Date: 19-Dec-2025
Our Ref: 2025/93365

**Application for a non-material amendment following a grant of planning permission,
Town and Country Planning Act 1990**

**Non material amendment to previous permission 2009/93382 for erection of retail
development
Cross Rink Street, Batley, WF17 6BH
Application Number: 2025/93365**

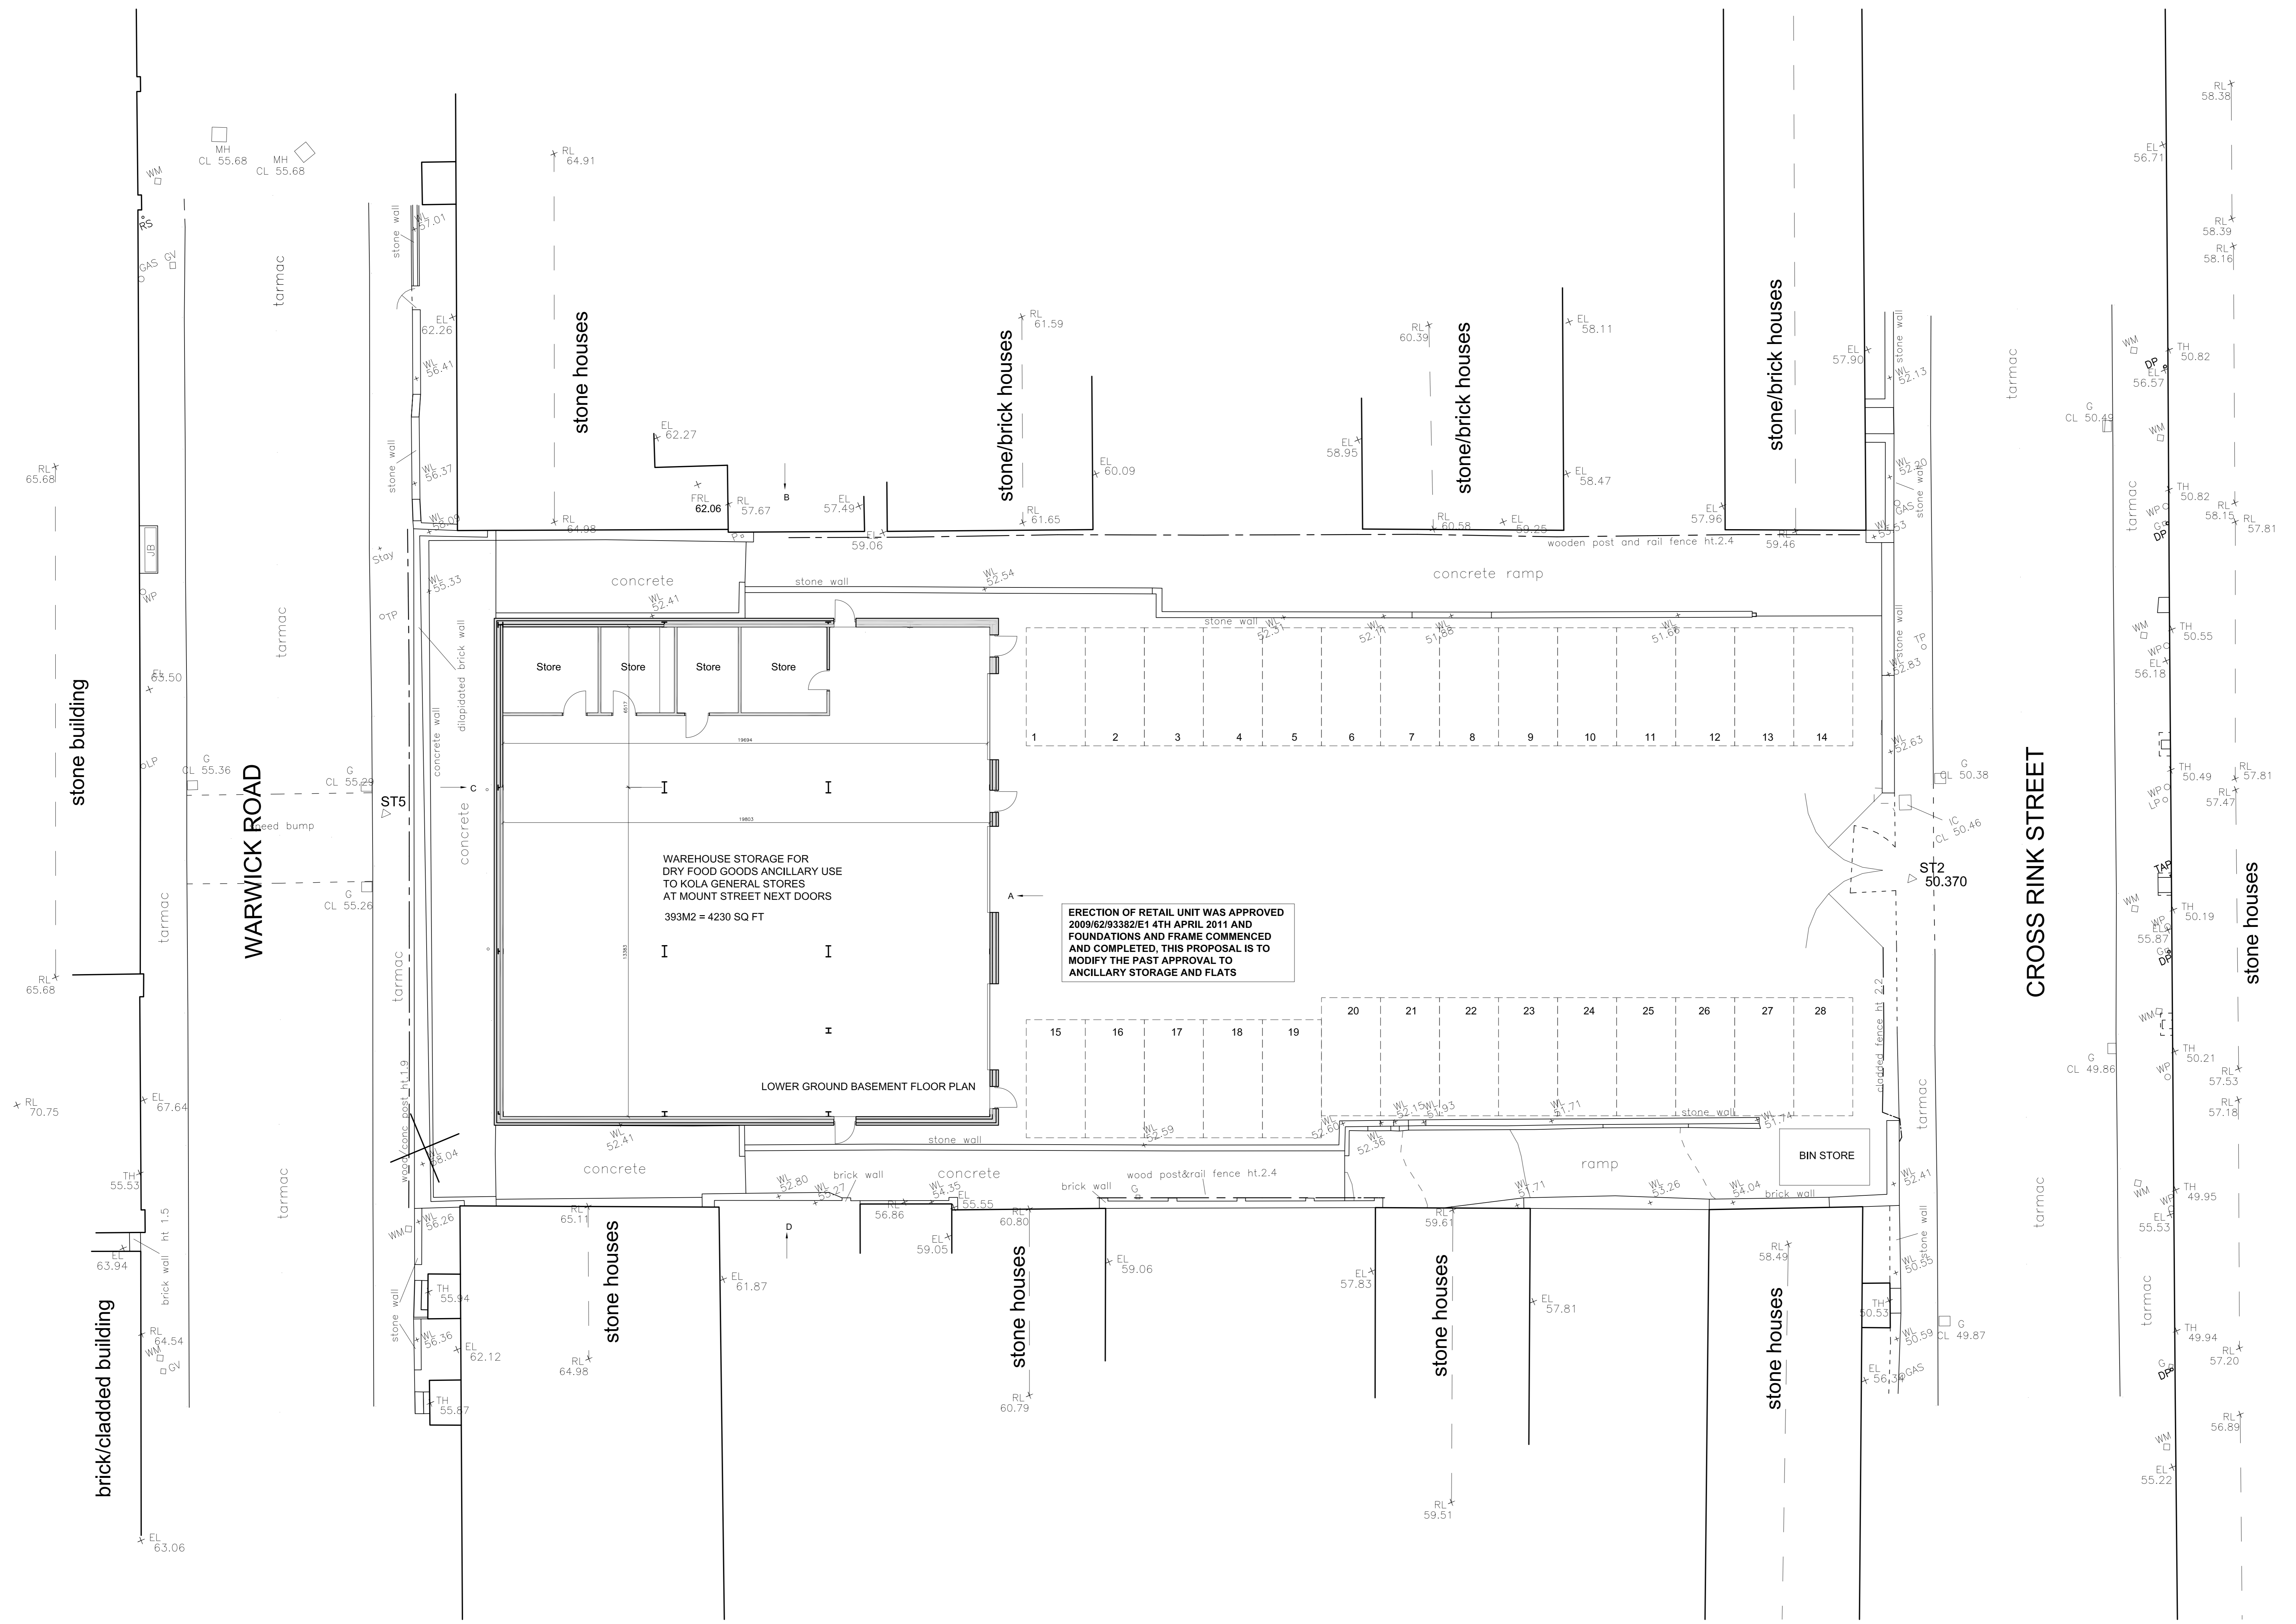
- Proposed Floor Plans, Drawing No. 24.2782.04, received 11/12/2025.
- Proposed Site Plan, Drawing No. 24.2782.03, received 11/12/2025.

The proposed changes to the permitted scheme would result in the development falling outside of the description of the development as set out on the decision notice. This, in addition to the level of changes proposed to the internal and external elevations and layout of the site, are considered to be material in nature.

The application for a non-material amendment is hereby refused.
